from
**Southern
Water**

Our ref
PLAN-039758

Proposal: 1 No. 4 bedroom detached dwelling with a detached 3 bay garage (2 open bays and 1 enclosed), associated foul field drain, storm soakaway, new front boundary treatment, roof mounted PV & Ground Source Heat pump System (resubmission following AL/32/19/PL). This site is in CIL Zone 3 and is CIL Liable as new dwelling.

Site: AL/66/21/PL: - Land Rear (South) of Sundown, Littleheath Road, Aldingbourne BN18 0SR.

DRAWING TITLE
Proposed Site Plan
(Incl Location Block Plan)

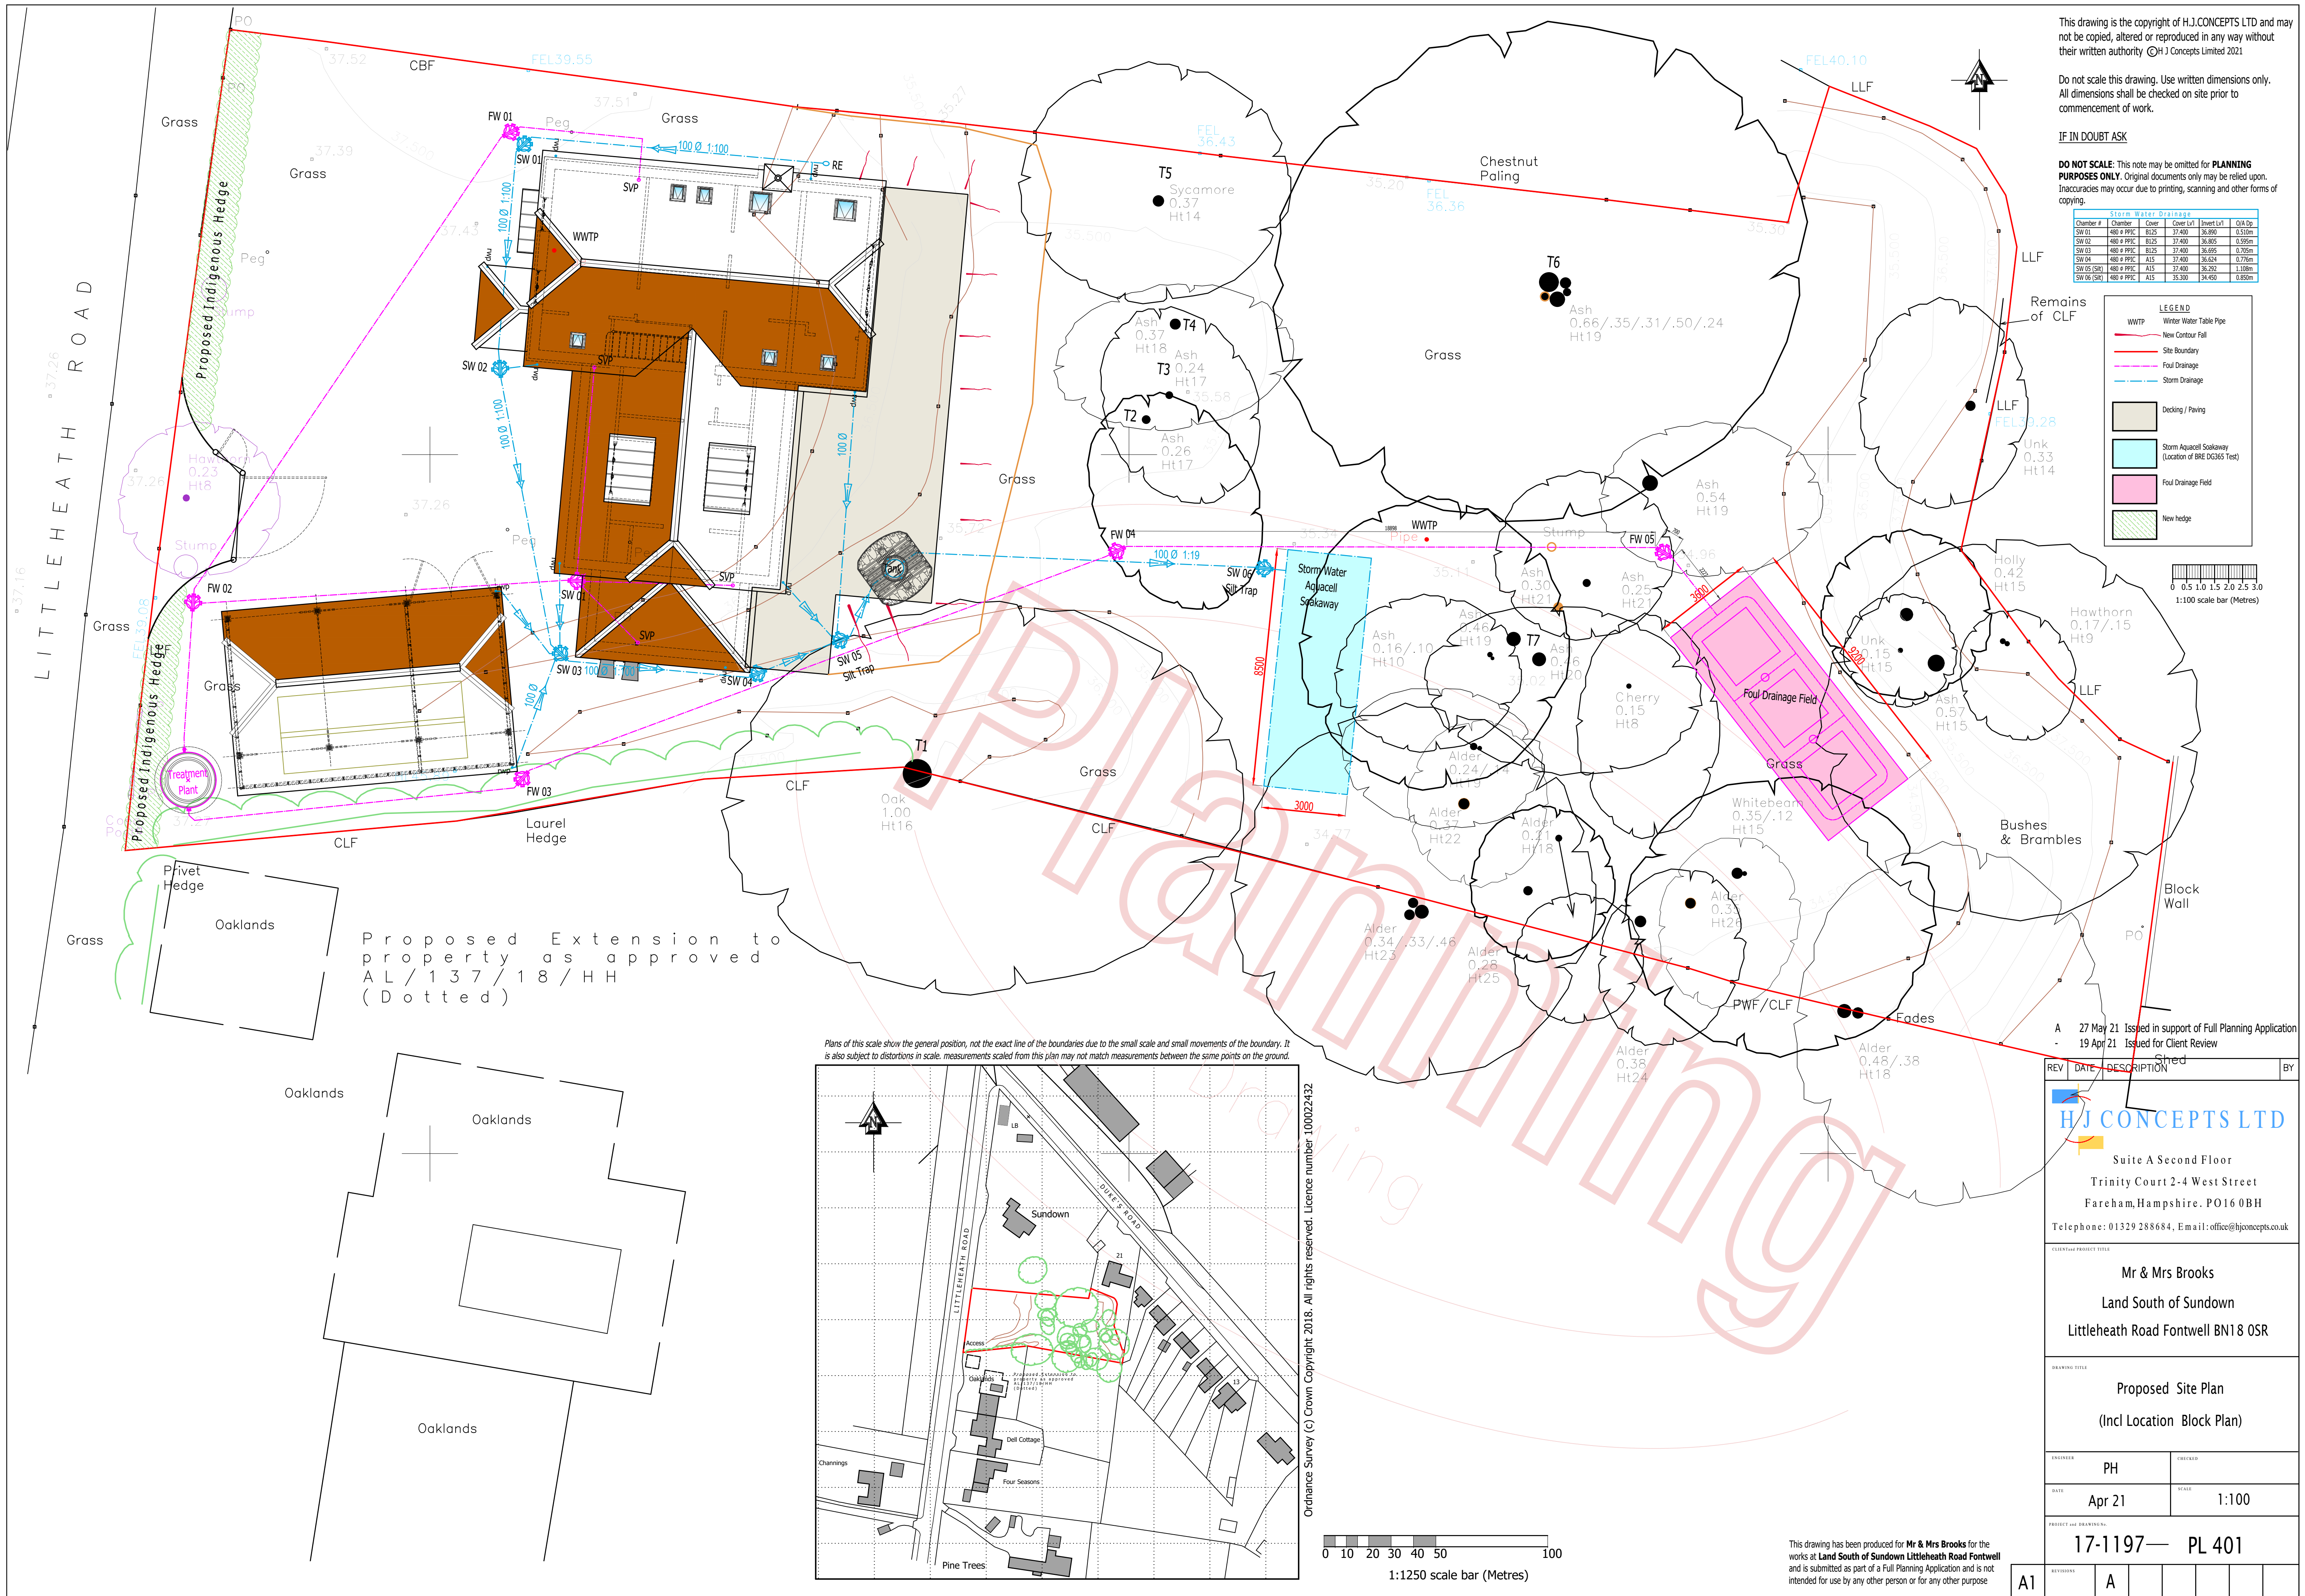
Southern Water would not support the proposals for a septic tank or private treatment plant in the presence of a public foul sewerage network in the close vicinity of the development site. The foul sewerage shall be disposed in accordance with Part H1 of Building Regulations hierarchy found at: gov.uk/government/publications/drainage-and-waste-disposal-approved-document-h

It may be possible for the flows from the proposed development to be connected to a nearby public sewer. To investigate this option the applicant should identify, in consultation with Southern Water, the nearest practical point of connection to the public sewerage network.

The Environment Agency should be consulted directly by the applicant regarding the use of a private wastewater treatment works which disposes of effluent to sub-soil irrigation.

The Council's Building Control officers or technical staff should be asked to comment on the adequacy of soakaways to dispose of surface water from the proposed development.
